**Consultation Response from KC,
Lead Local Flood Authority**

2025/91870 Land off, Roslyn Avenue, Netherton, Huddersfield, HD4 7EW

Date Responded: 27th August 2025

Kirklees Flood Management & Drainage acting as Lead Local Flood Authority requires ADDITIONAL INFORMATION before submitting a final consultation response.

drawing title:
Foul and Surface Water Drainage Layout Plan

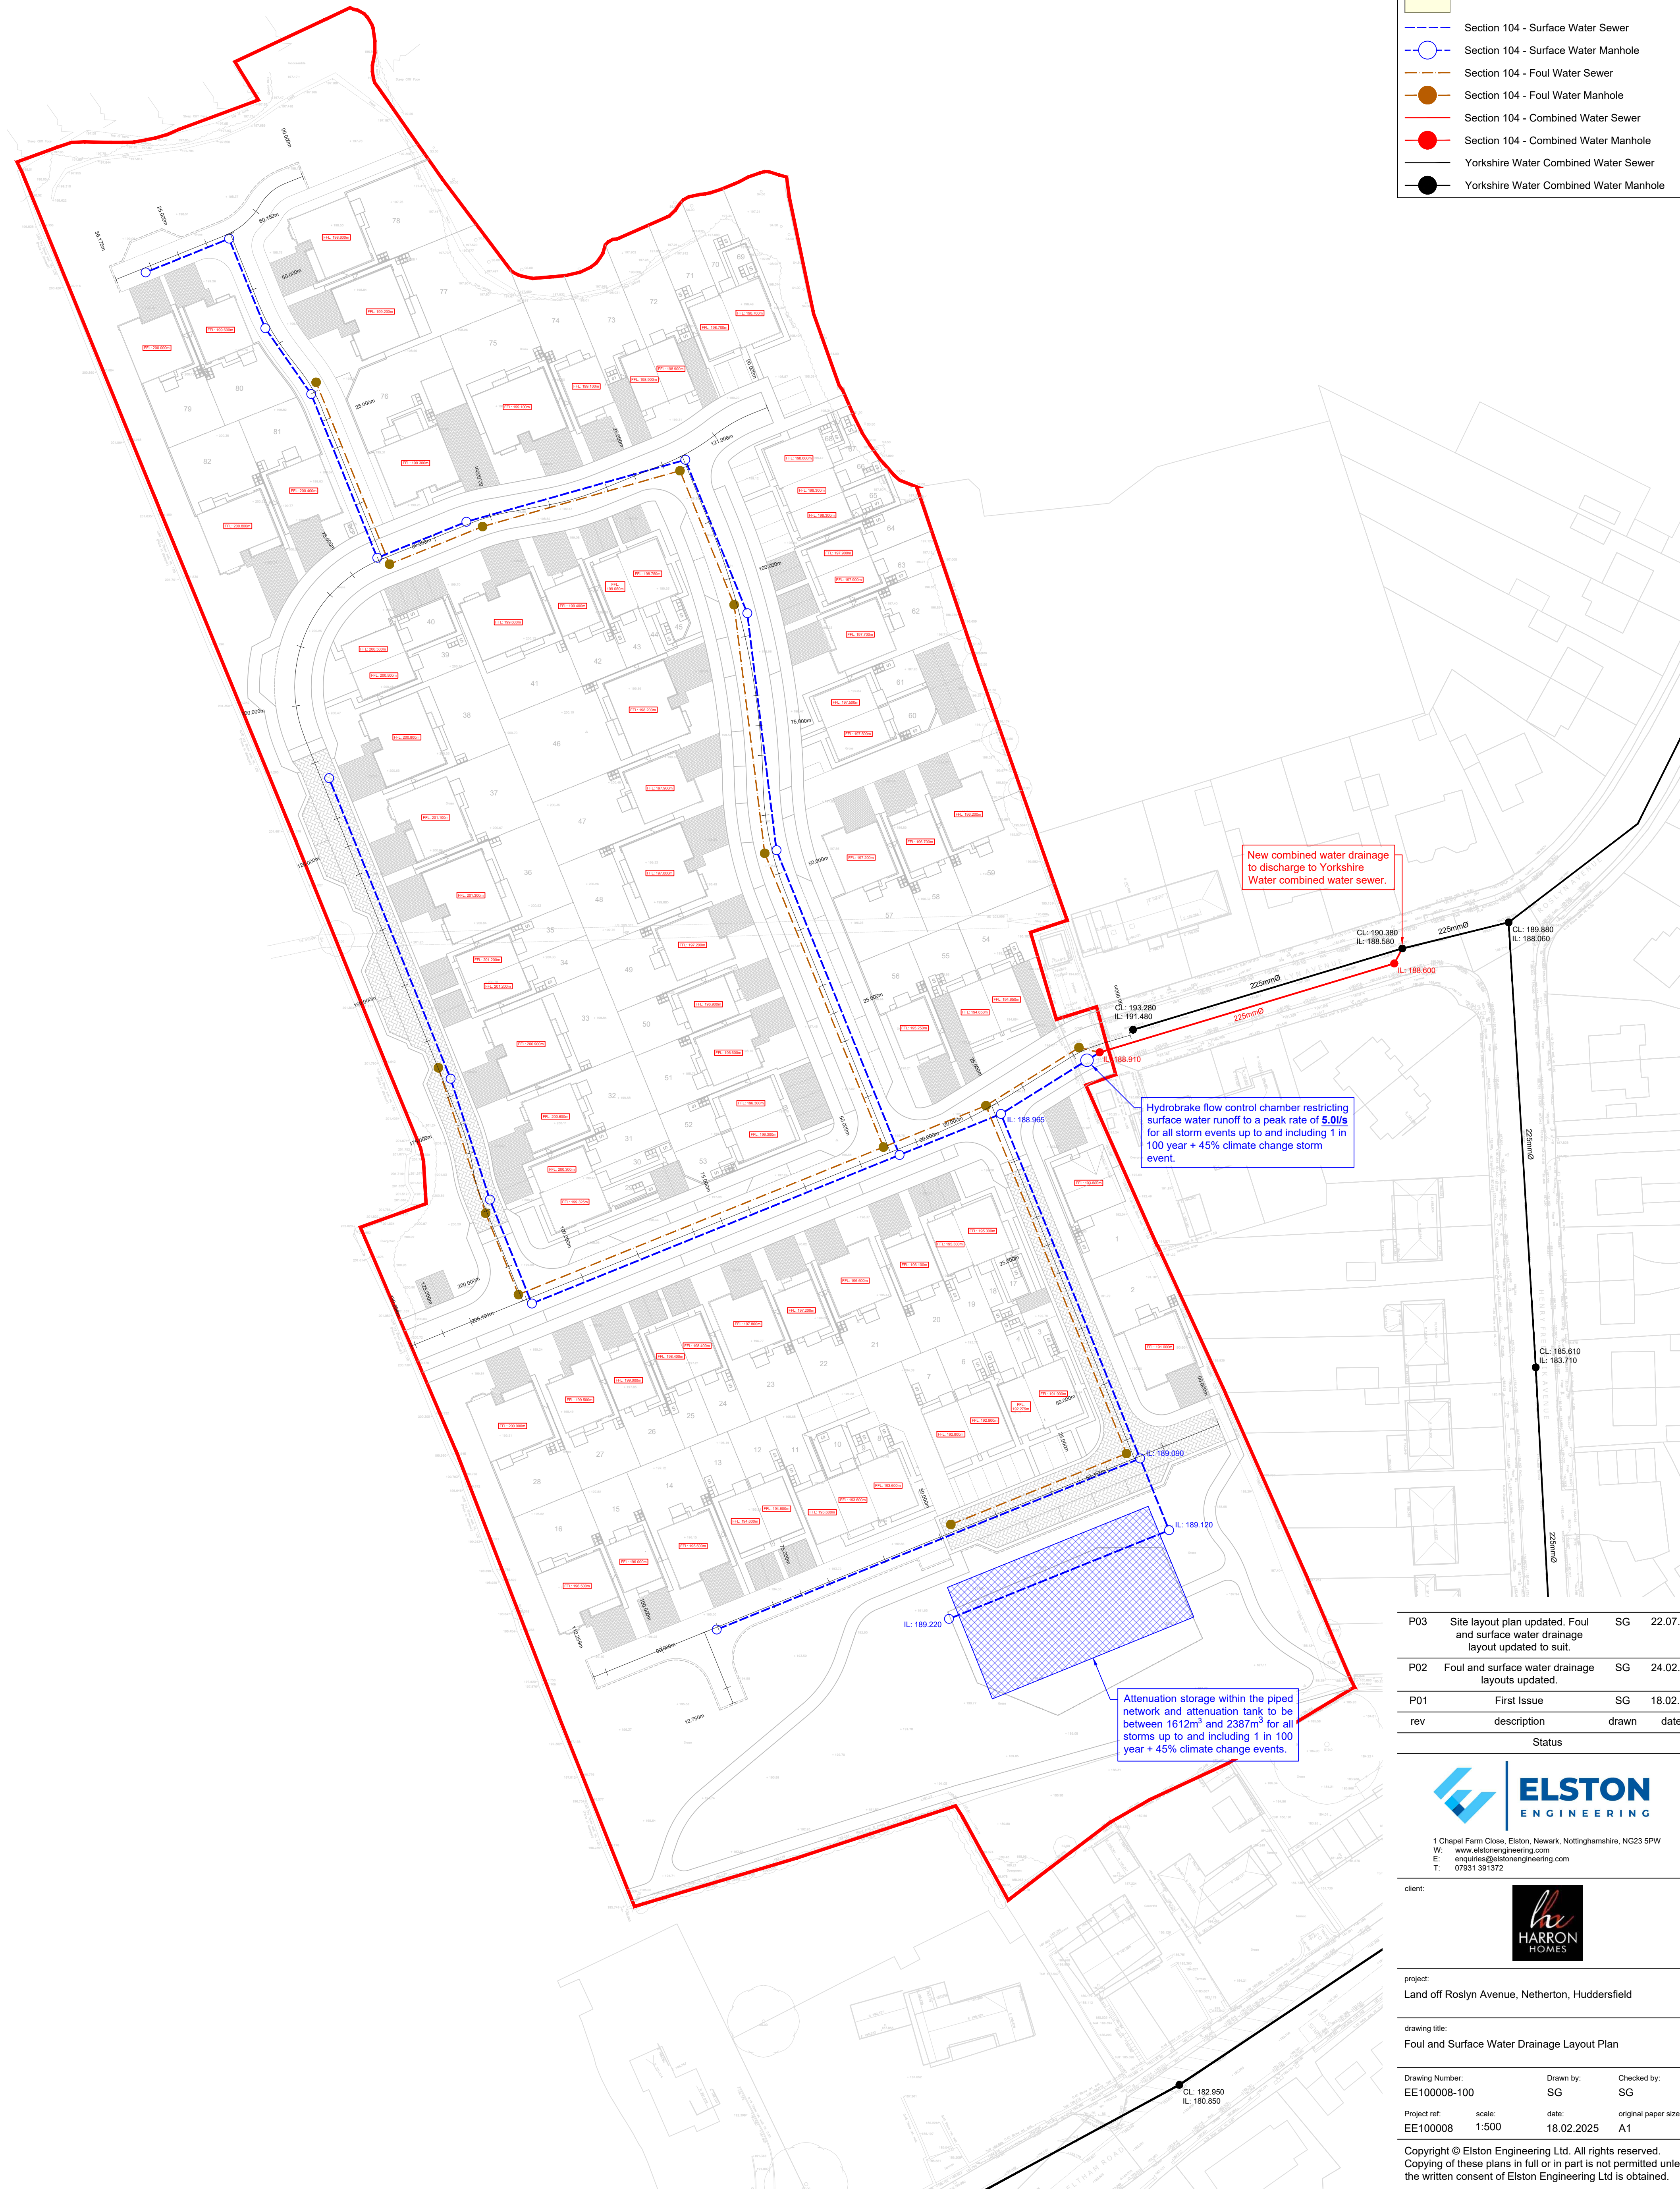
Whilst there is no objection to the variation in conditions applied for, as layout is not a reserved matter, a clear flood routing strategy is required, at least to demonstrate feasibility, is required before conditions 21, 22 and 23 can be transferred from the original application 2023/93503.

Condition 22 is the flood routing condition which now needs a degree of certainty through a fixed layout as exceedance events and blockage scenarios are considered.

It does appear that flood routing that avoids property curtilage and used road and open space should be achievable on this site. In addition, however it is important to demonstrate that surrounding properties can be protected by using the public right of way at the southeast corner of the site as a safe route into the existing built environment. Some engineering may be required given the narrow width of the footpath.
